From: Laura Gibbons <Laura.Gibbons@arun.gov.uk>
Sent: 24 November 2020 16:03
To: Planning.Responses <Planning.Responses@arun.gov.uk>
Cc: Anita Gardner <Anita.Gardner@arun.gov.uk>
Subject: CM/48/20/DOC- Bairds Farm Shop, Field Rear of Crookthorn Lane Climping BN17 5SN

Engineers Comments Regarding Condition 5- Surface Water Drainage

We do not recommend discharge of condition 5 at this time.

SCALE @ A1 As Noted	ENGINEER MBD
PROJECT NUMBER 2868	DRAFT NJ
STATUS S2	APPROVED TST
DATE April 18	
PROJECT ORIGIN BCH ICS	DWG NO / REVISION 003 P07
PHASE 01	
LEVEL XX	
TYPE DR	
ROLE C

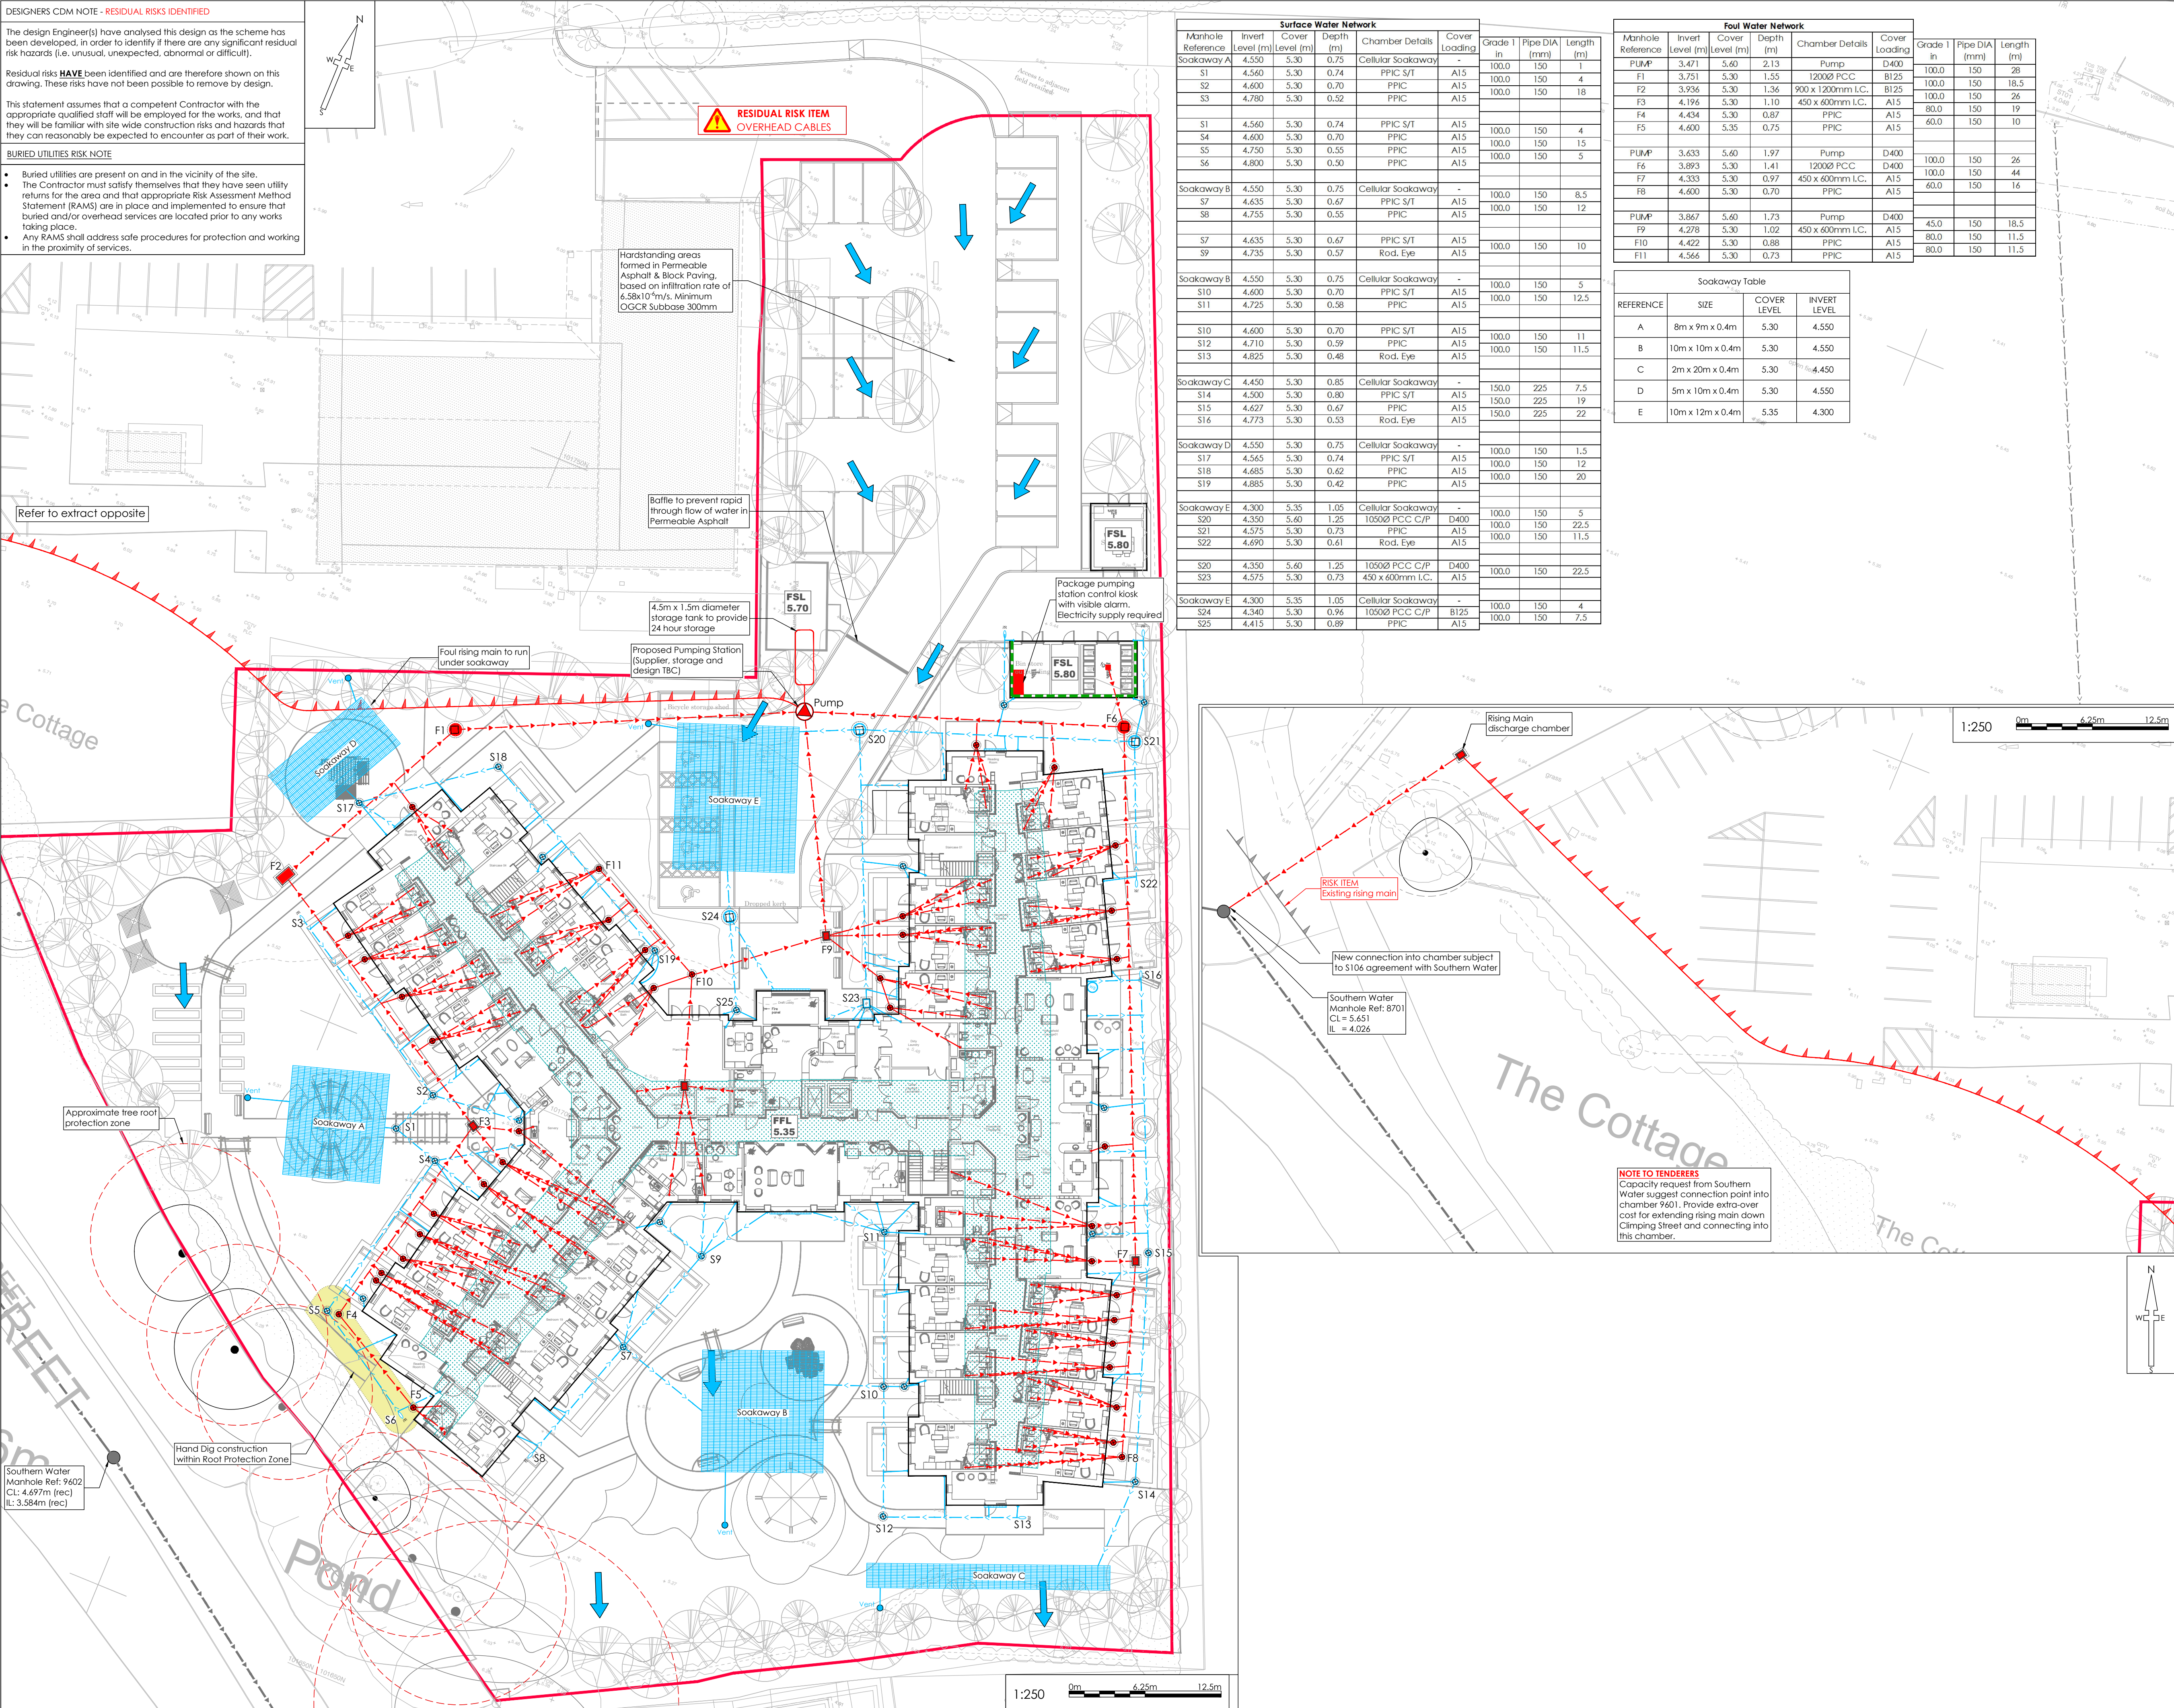
The proposals submitted include pumping of surface water. Pumping must be avoided unless it is demonstrated that all possible alternatives are not feasible. Pumping is not sustainable, pumping stations are also prone to breaking and causing flooding.

The strategy submitted does not detail the maximum area that can be drained to infiltration. Please can this information be supplied.

If it is demonstrated that all water cannot be infiltrated then we will need to see that all other means of gravity discharge have been considered. From looking at our mapping it appears that there are alternative potential locations for surface water drainage disposal including:

1. The culverted ordinary watercourse that runs north south along the developments eastern boundary. We believe this may be what the applicant refers to as a private surface water sewer, however our records indicate the culvert is further west. A connection may be more suitable at a different location- i.e. further south.
2. The pond within the application boundary- does this have an outlet?
3. The ordinary watercourse to the west of Climping Street

It is also evident from the proposed overflow connection to the culverted ordinary watercourse that a gravity connection is feasible to some extent and that it may be that storage is not being kept sufficiently shallow.

All three of these locations appear to be to the low parts of the site. Please can the applicant consider the above potential discharge locations.
